Charlotte Storm Water  
600 East Fourth Street  
Charlotte, N C 28202-2844

## *Rezoning Petition Review*

**Rezoning Petition #:** 20-11

MARGARET WALLACE SUBDIVISION
 CHARLOTTE, NORTH CAROLINA
REZONING SITE PLAN

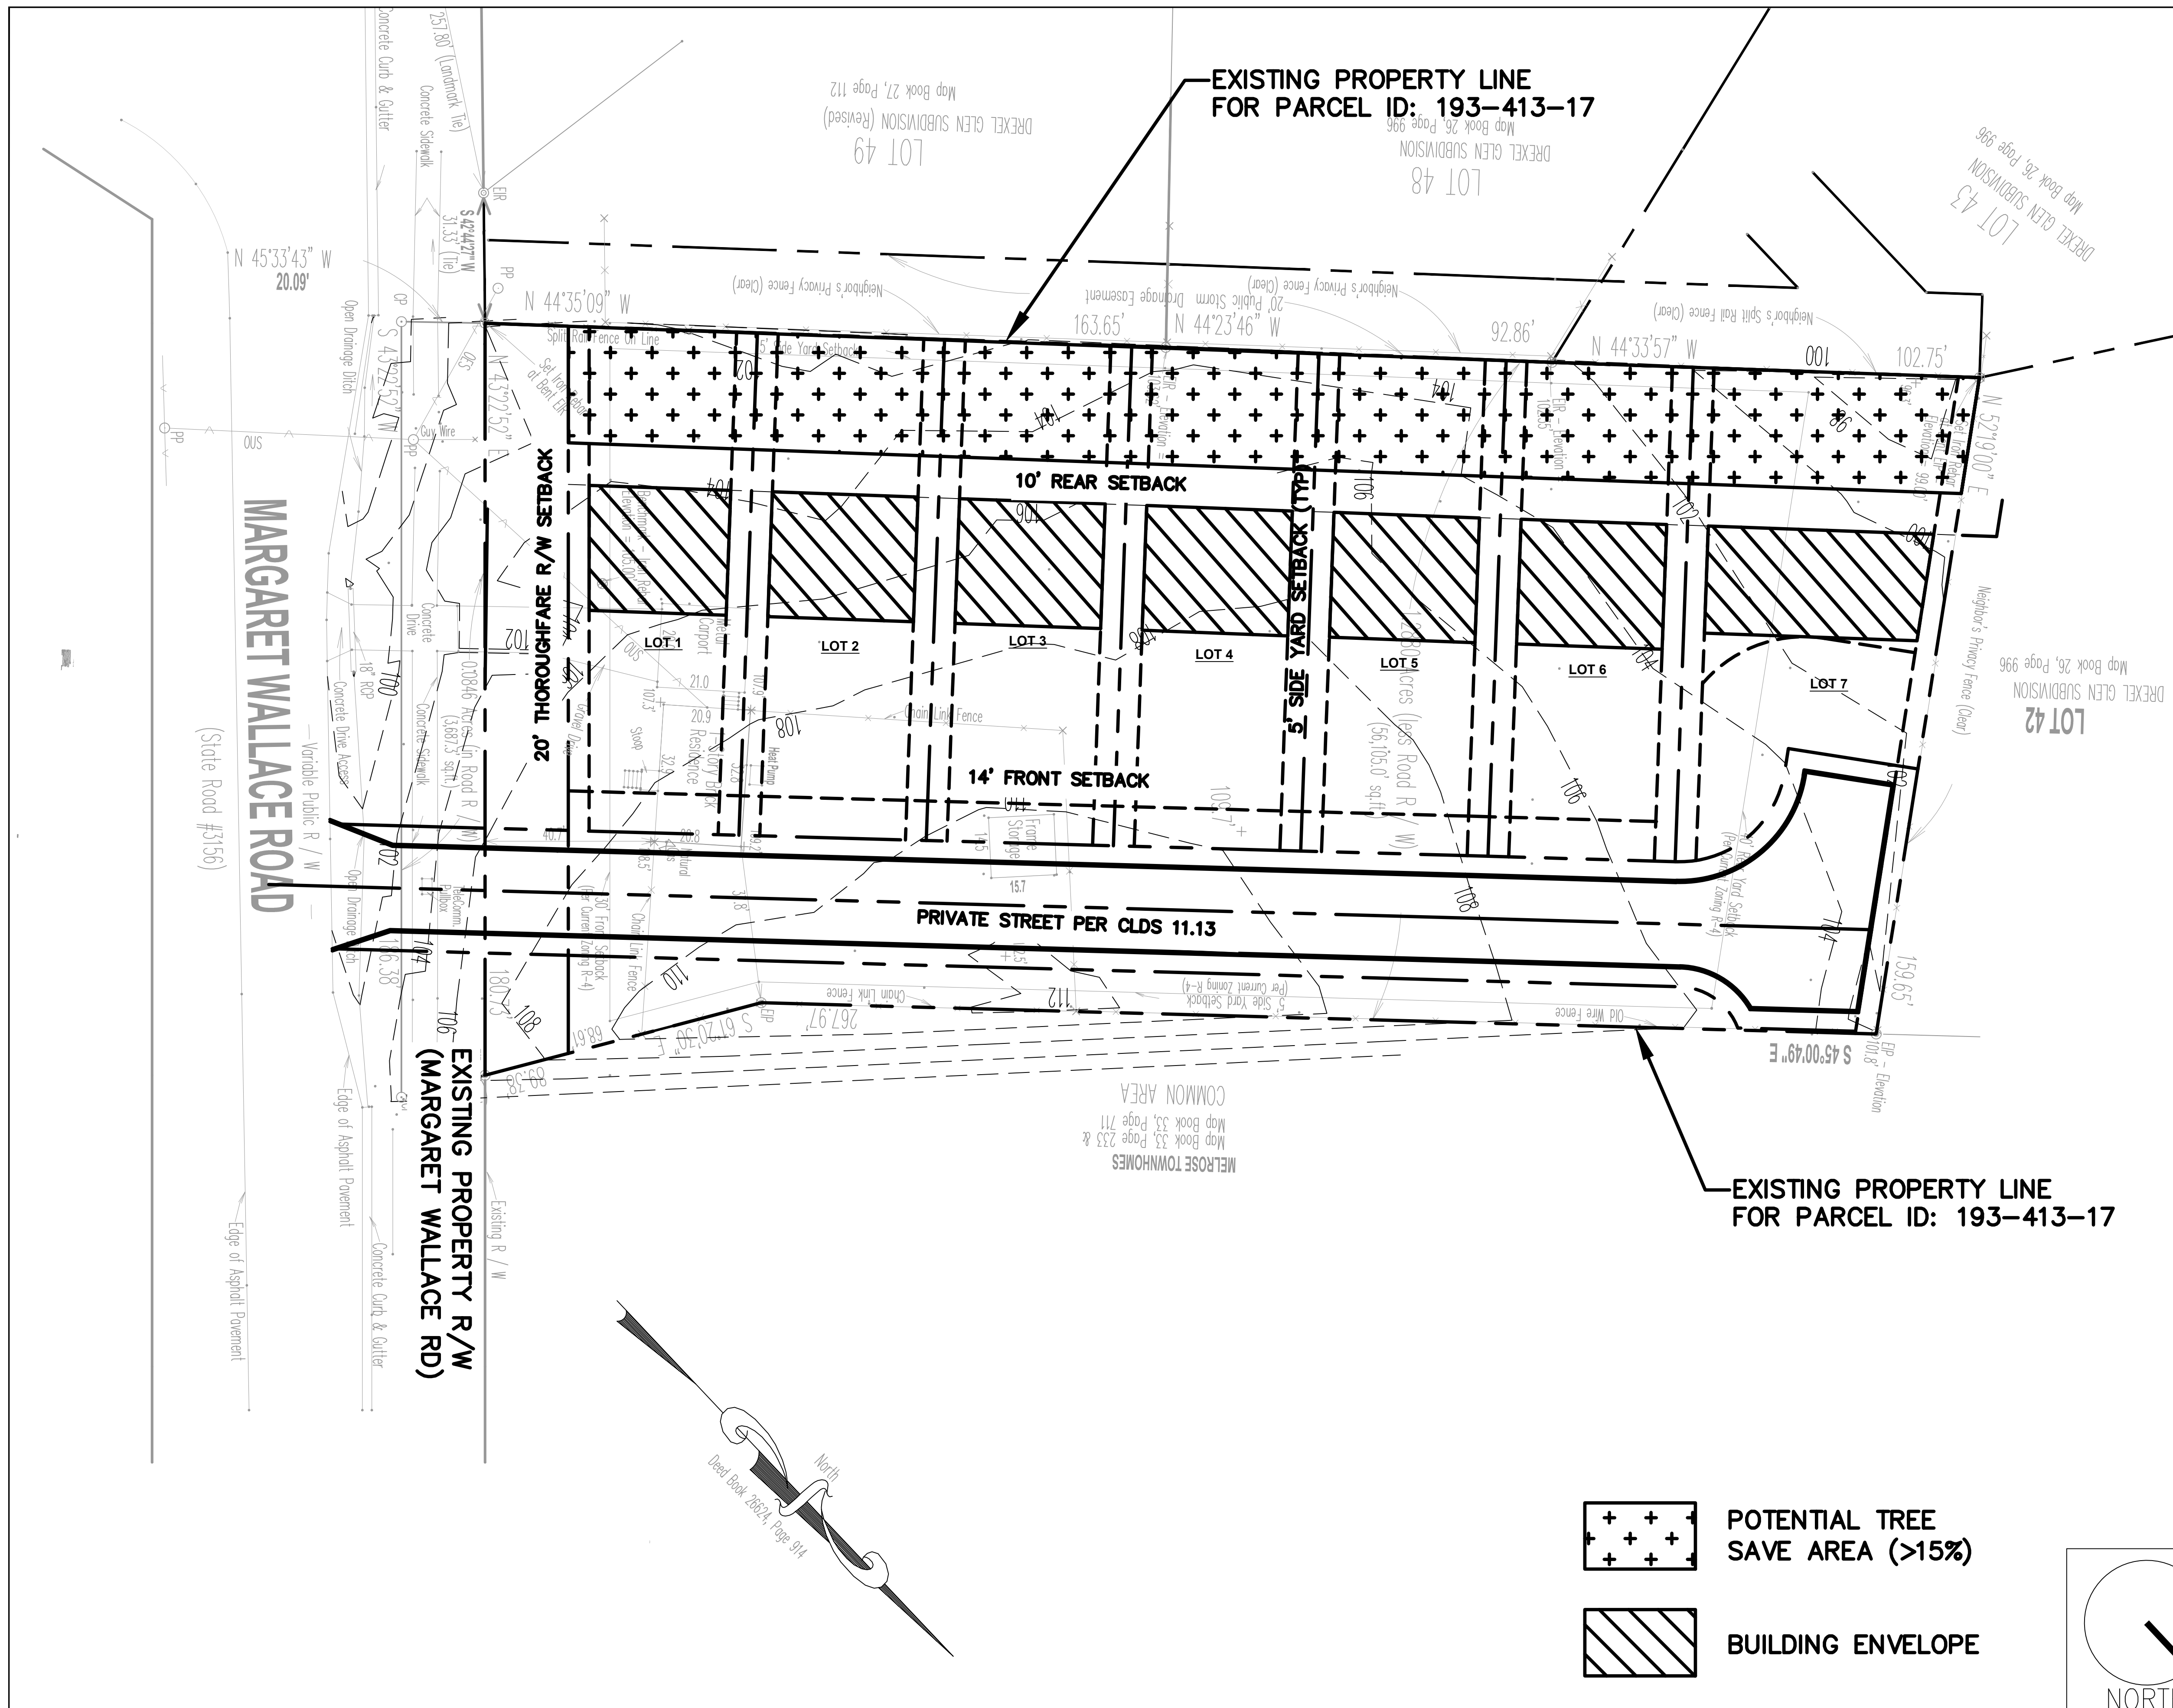
**Concerning Storm Water:** Please add the following notes to the site plan under *Environmental Features*: “*The petitioner shall tie-into and analyze the adequacy of the existing storm water conveyance to the nearest public right-of-way. If the existing storm water conveyance is found to be inadequate, the Petitioner shall make a good faith effort to improve the storm water conveyance or mitigate the storm water discharge.*”

**Due to revisions (3/23/20):** Please add the following notes to the site plan under *Environmental Features*: “*The petitioner shall tie-into and analyze the adequacy of the existing storm water conveyance to the nearest public right-of-way. If the existing storm water conveyance is found to be inadequate, the Petitioner shall make a good faith effort to improve the storm water conveyance or mitigate the storm water discharge.*”
